Our ref: Residential flat building with in-fill affordable housing at 5-9 Cowan Road, St Ives (SSD-88948458)

Subject: Request for Additional Information

KEY

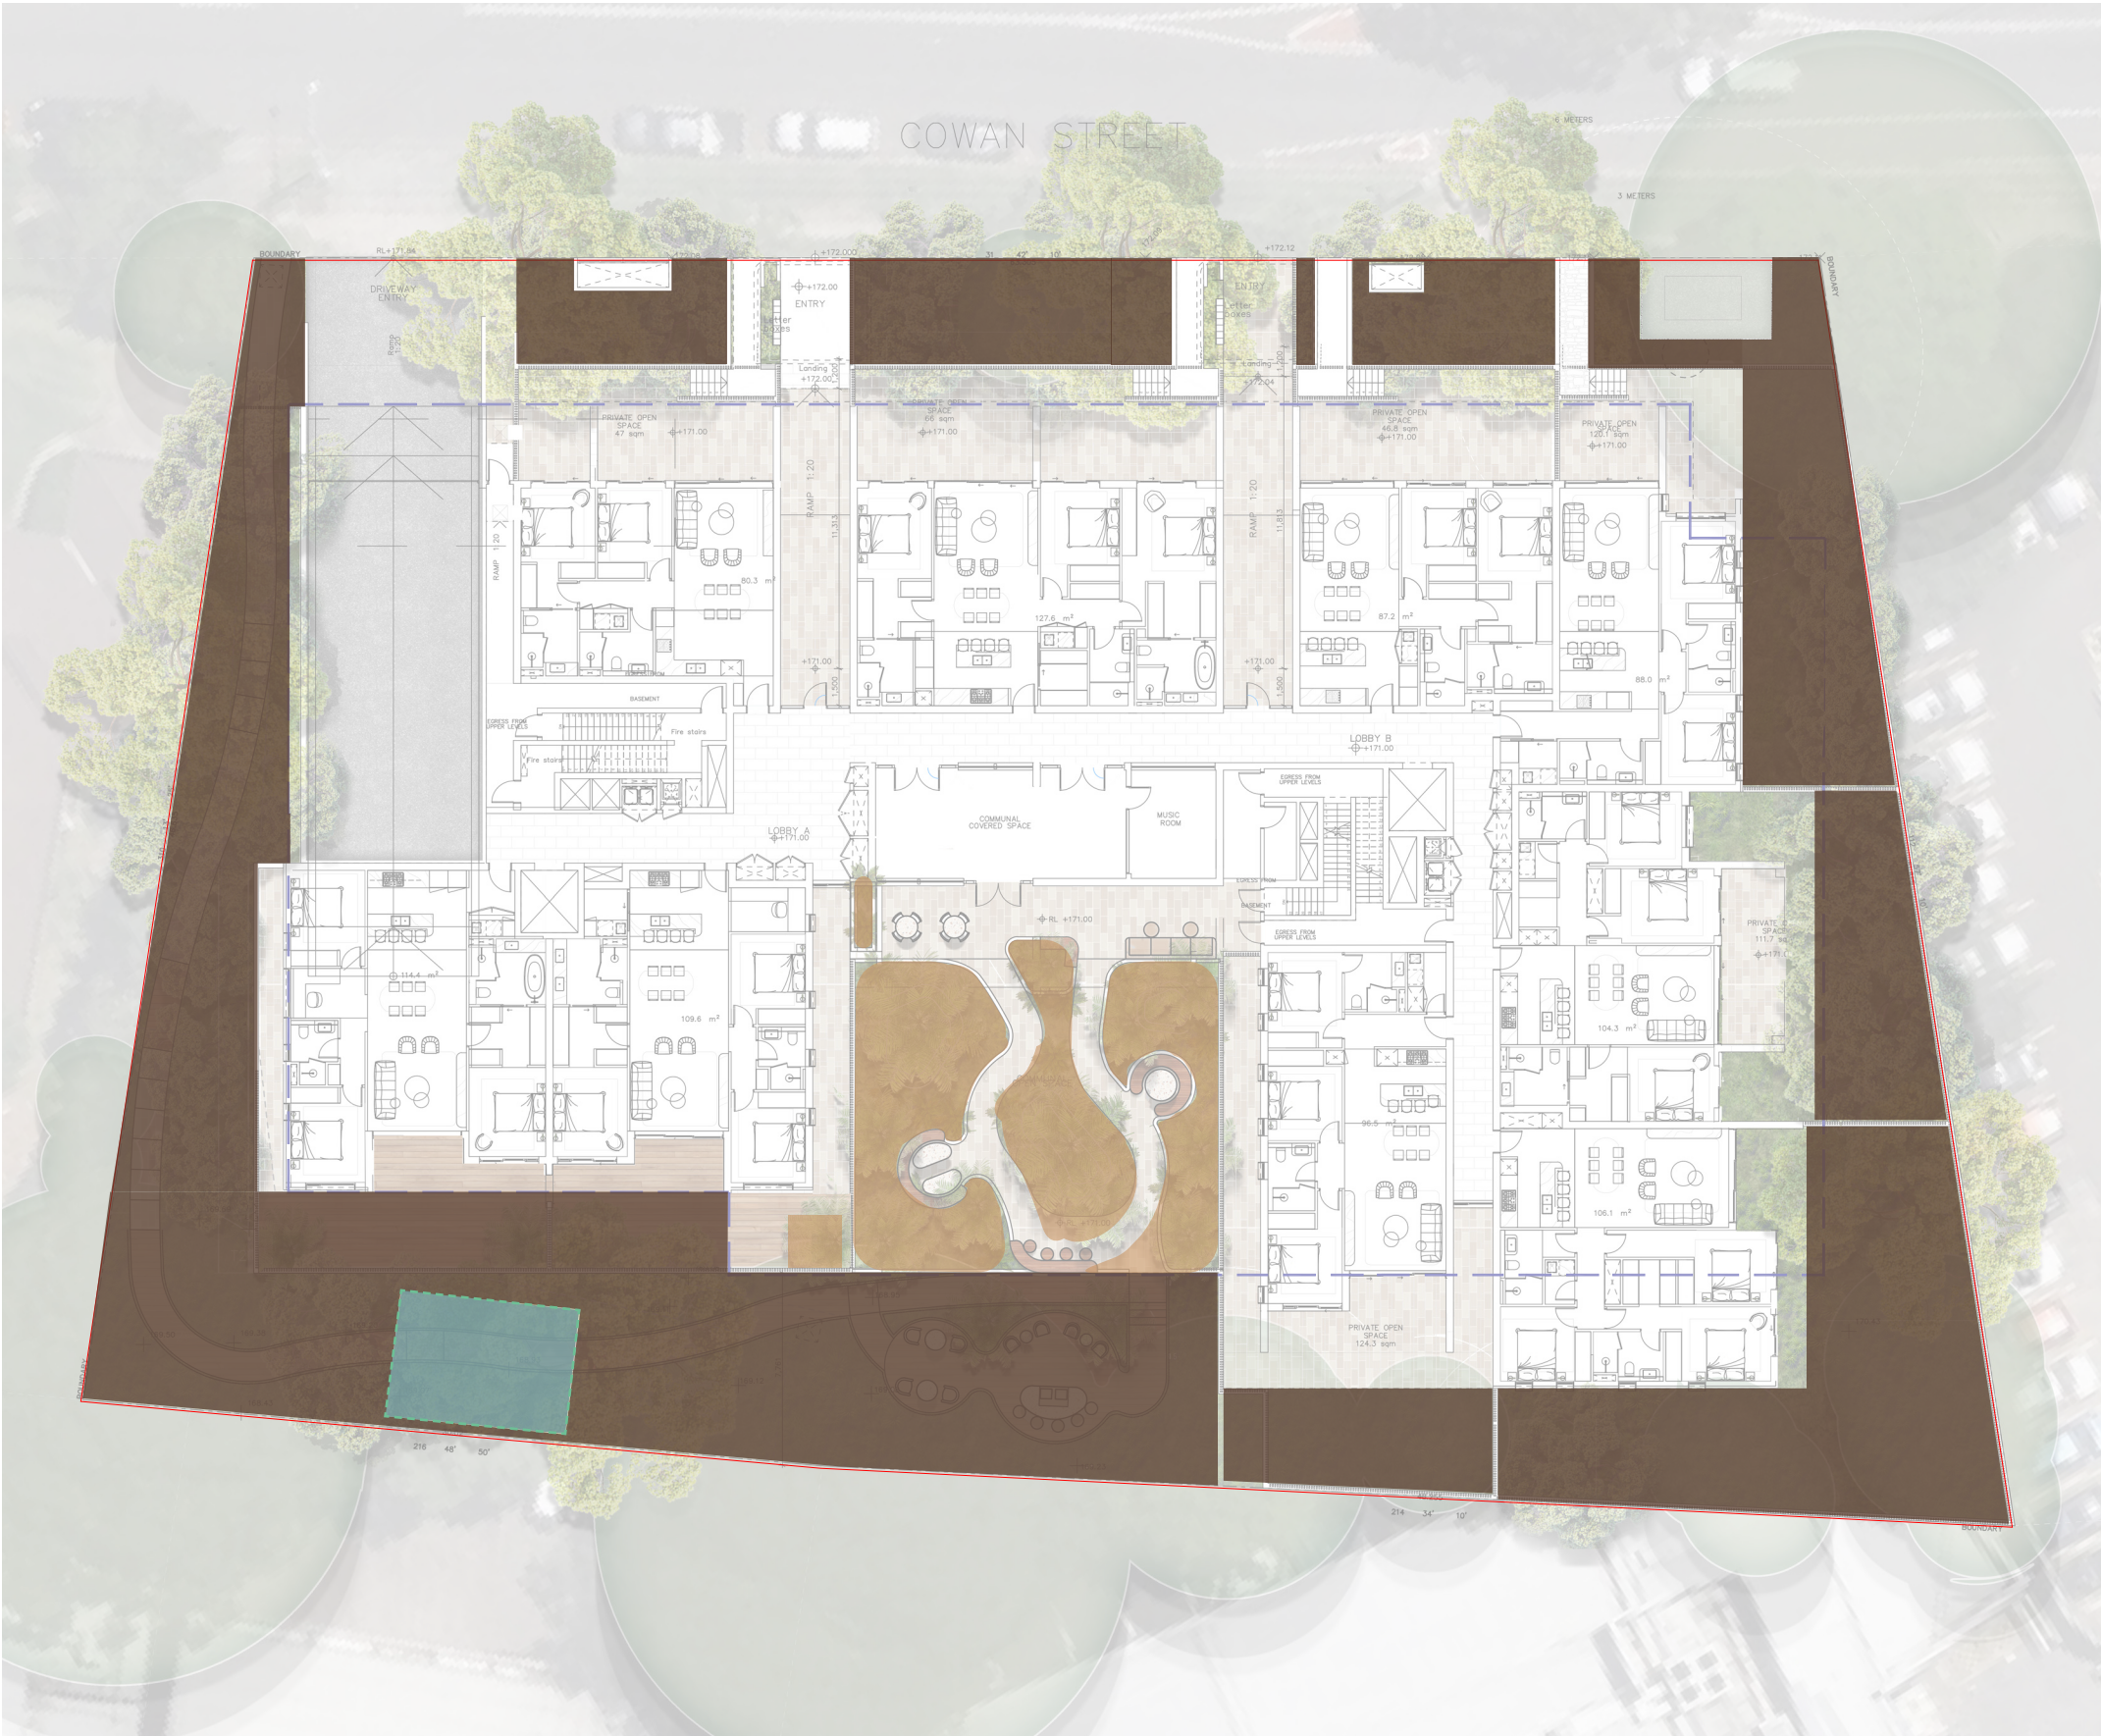
12. Revise the deep soil calculation plan (DA510) as it incorrectly calculates deep soil with dimensions of less than 6 m x 6 m to the eastern rear corner. In addition, ensure the footpath throughout the deep soil area is to be pervious to meet the definition of deep soil within the ADG.
